# KITTITAS COUNTY COMMUNITY DEVELOPMENT SERVICES

March 5, 2020

Subject: Determination of Incomplete Application  
Thunder Mountain Administrative Conditional Use Permit (ACU-20-00001)

**THUNDER MOUNTAIN, LLC**  
**CONCEPTUAL SITE PLAN**

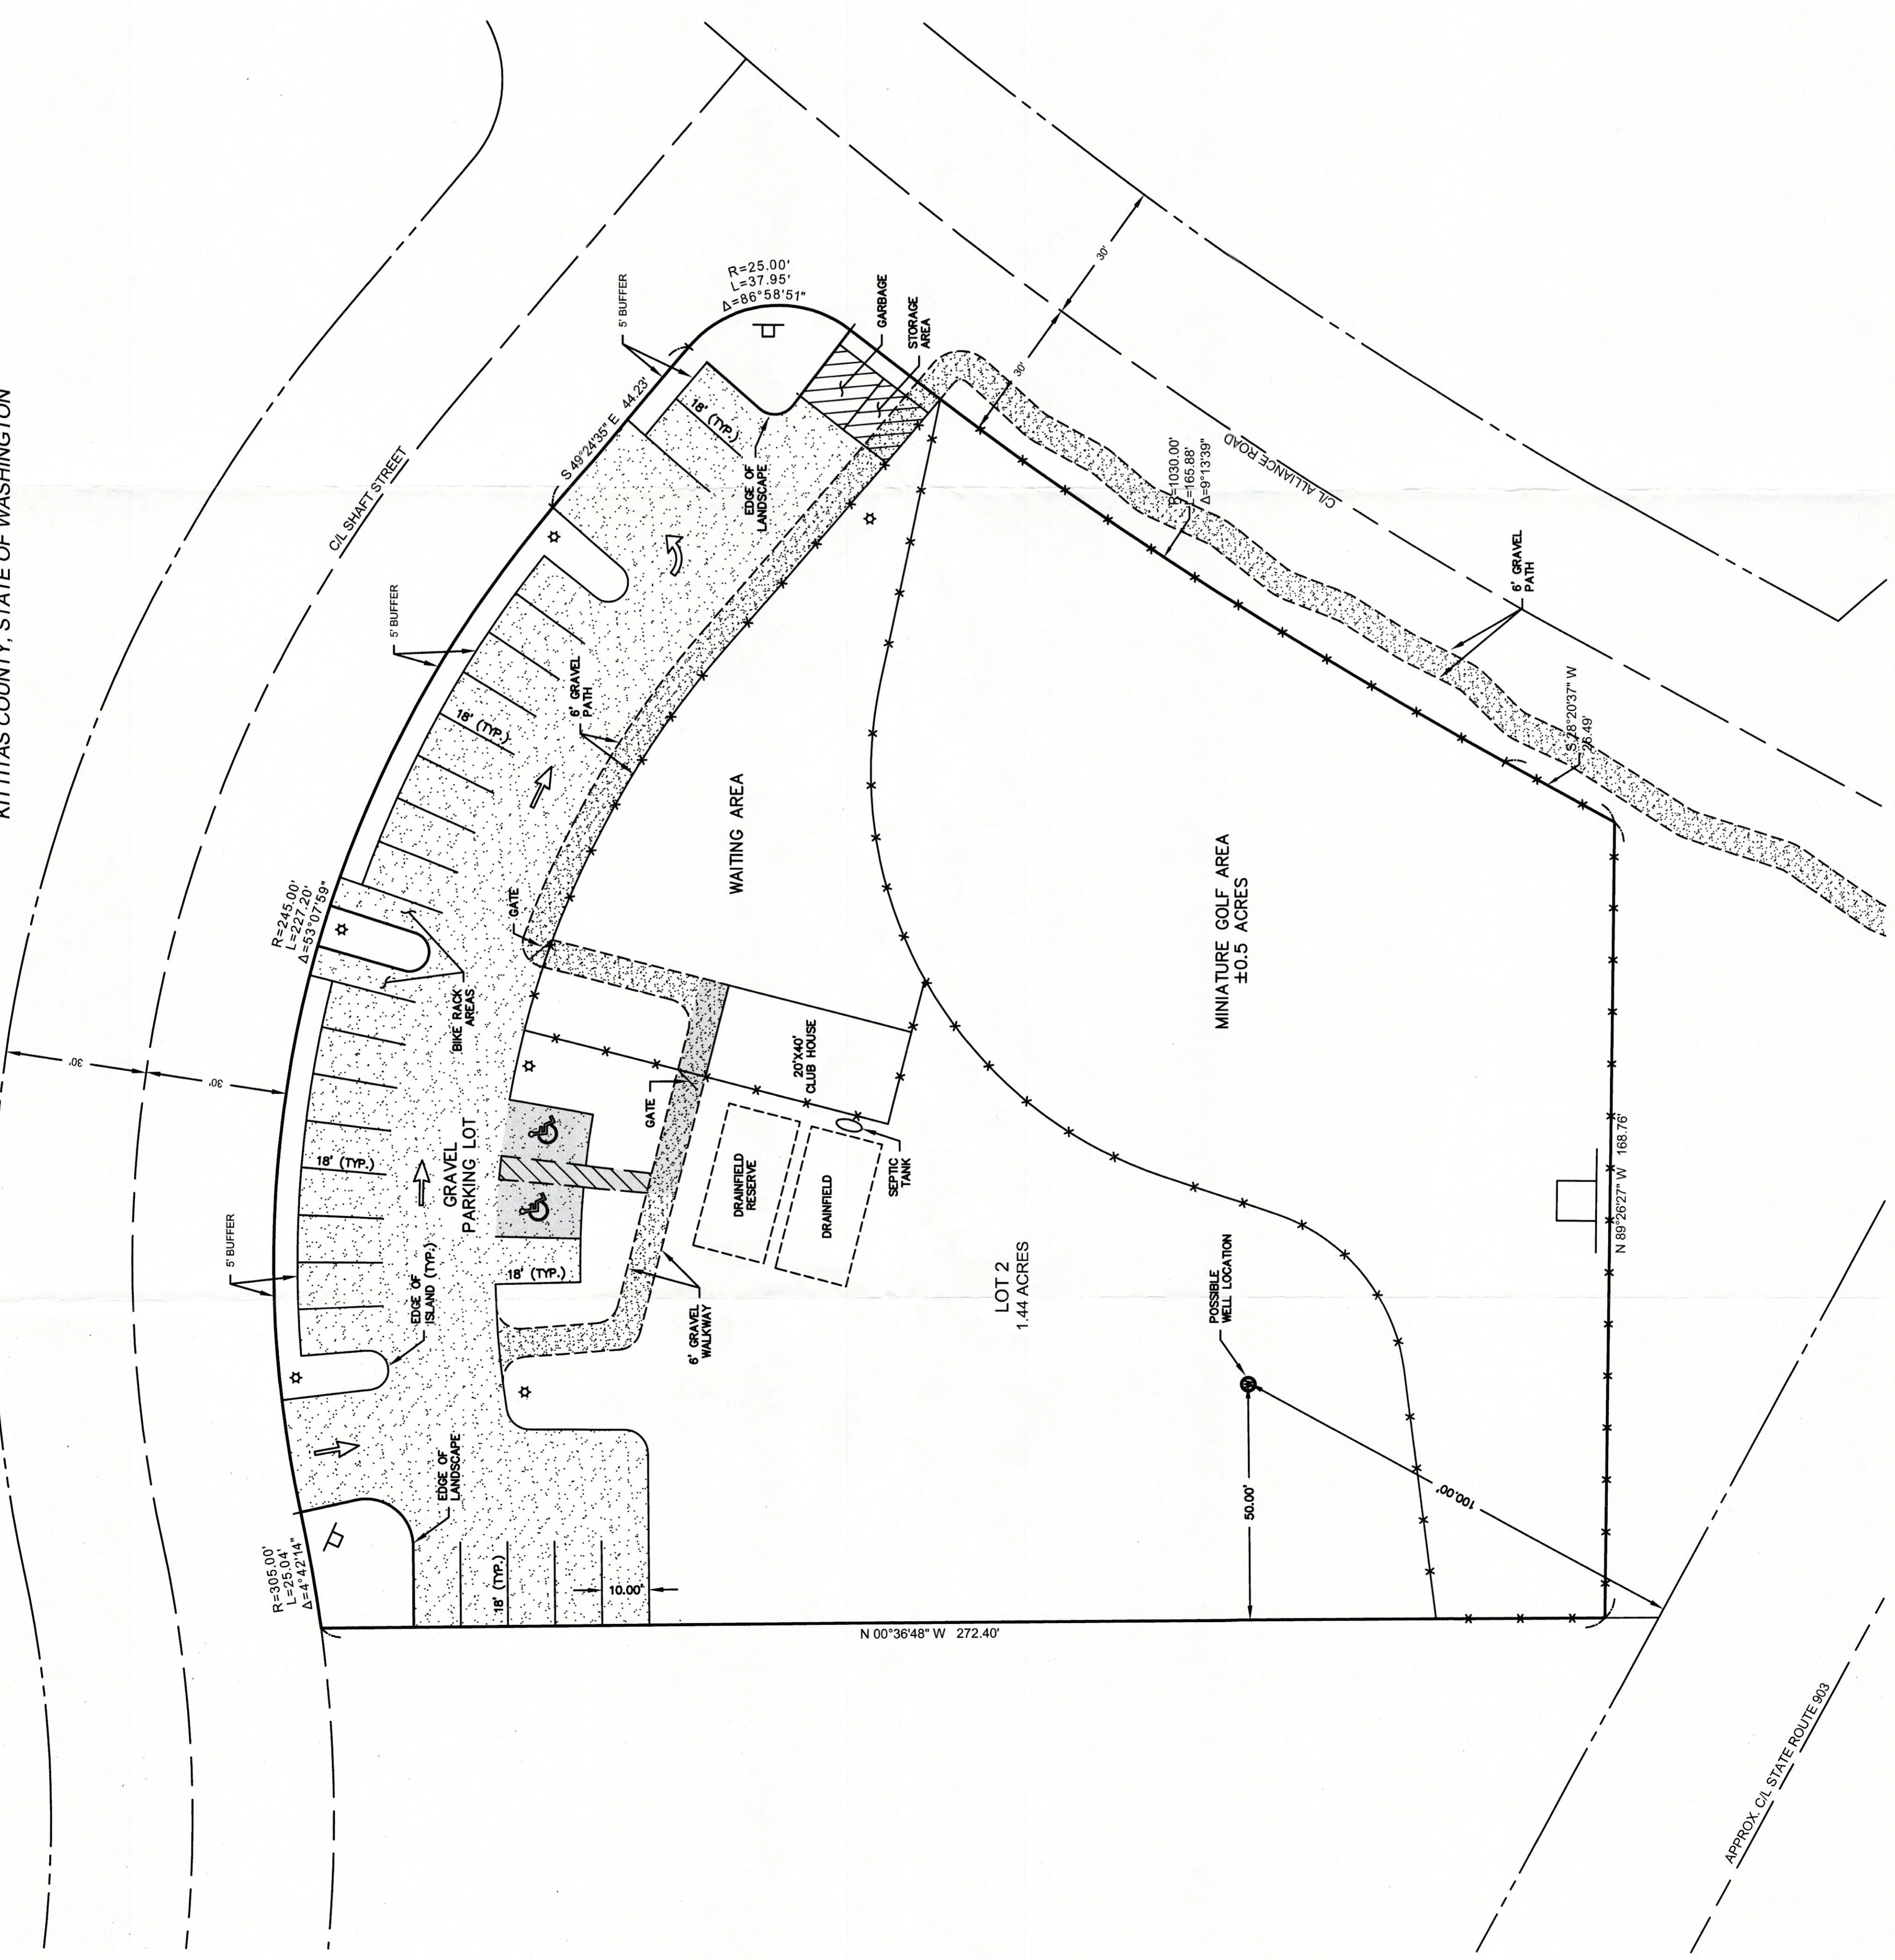
2. An updated site map showing the setbacks associated with the parcel. This can be shown as an offset from each property line. The property is zoned as Rural 5 and the setbacks are as follows: Front Yard – 25 feet and Side and Rear yard setbacks are 15 feet. Please Note: Kittitas County Code (KCC) 17.05.590 defines a "Yard, front" as "'Front yard" means any yard abutting a public or private street. (Res. 83-10, 1983)".
